Application No: M/54/21/HH
Site Address: 17 Sea Way Middleton-On-Sea PO22 7RZ
Description of works: Re-model and extend garage.

Thank you for your internet representation made on 25th May 2021 which has been recorded as no objection with the comments as follows:

DRAWING SCALE: 1:100 @A3
Proposed drive layout plan
DATE: Feb 2021
DRAWN: A. H. Sutcliff
DRAWING: 2106/PP/08 REVISION:

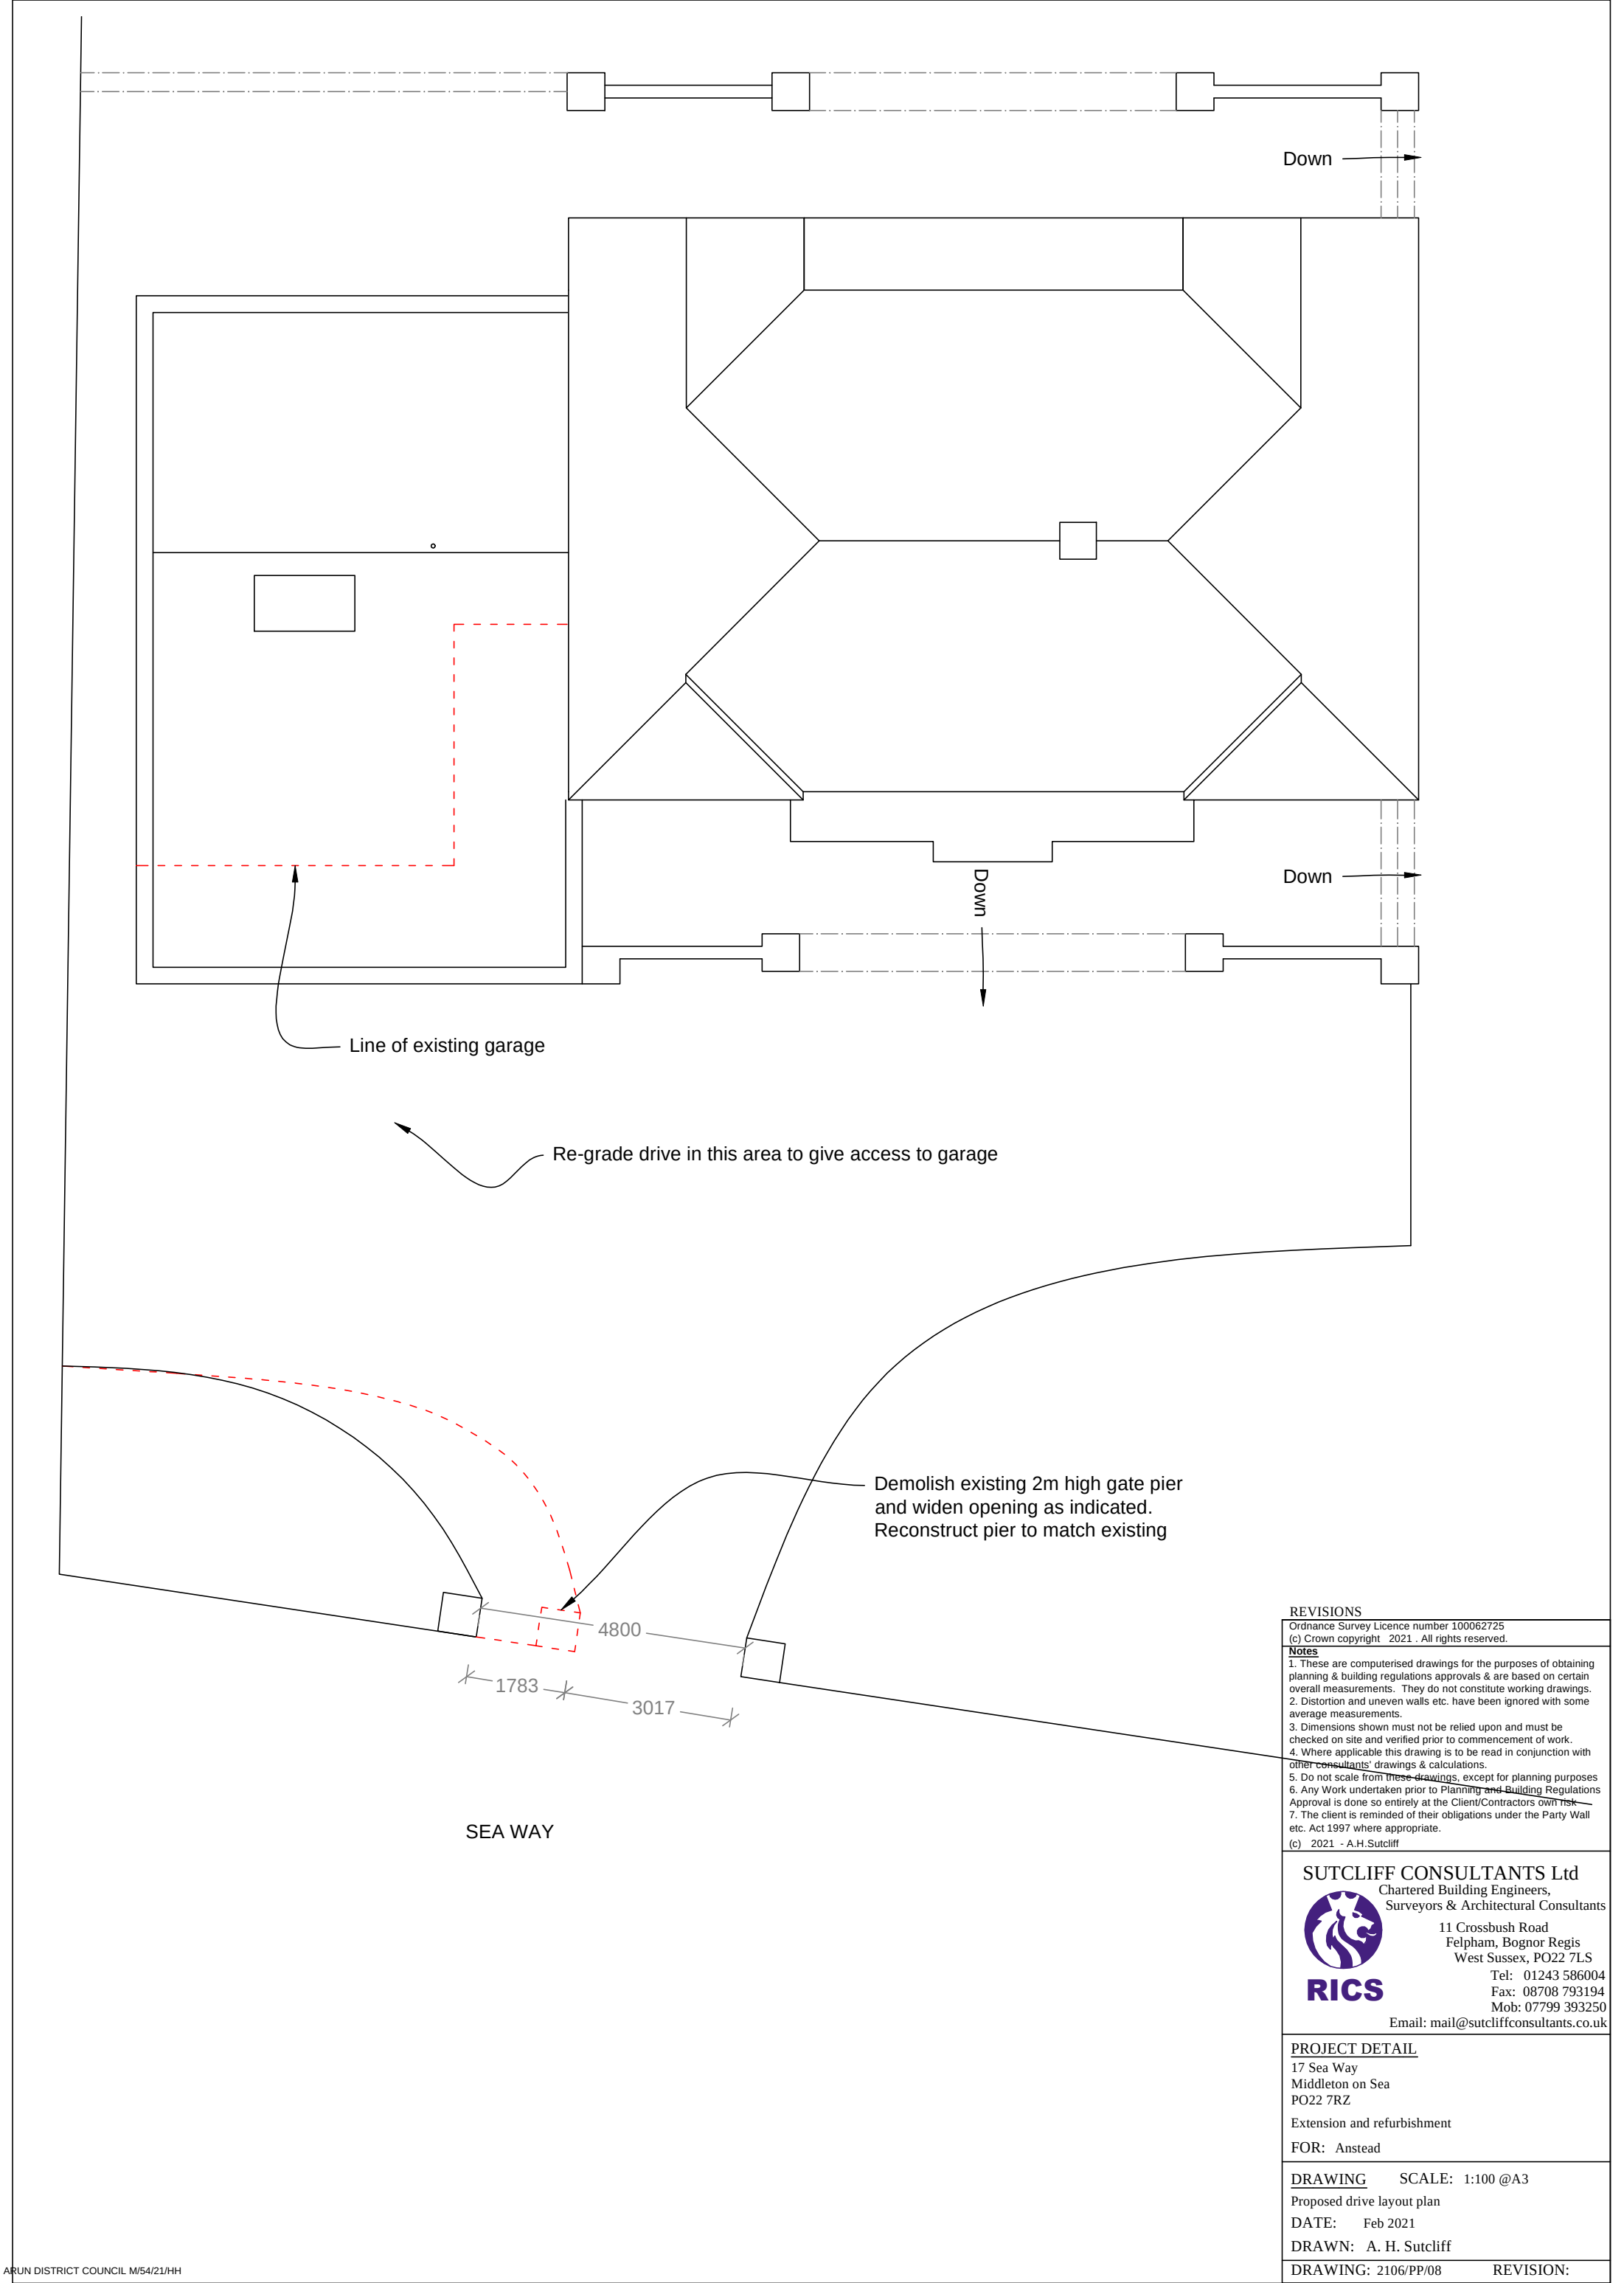
Whilst MOSA have no objection to the garage redesign and extension, we note that the submitted plans also indicate a significant widening of the driveway. ADC are advised that this will encroach onto MOSA land and would require MOSA's agreement which may not be forthcoming.
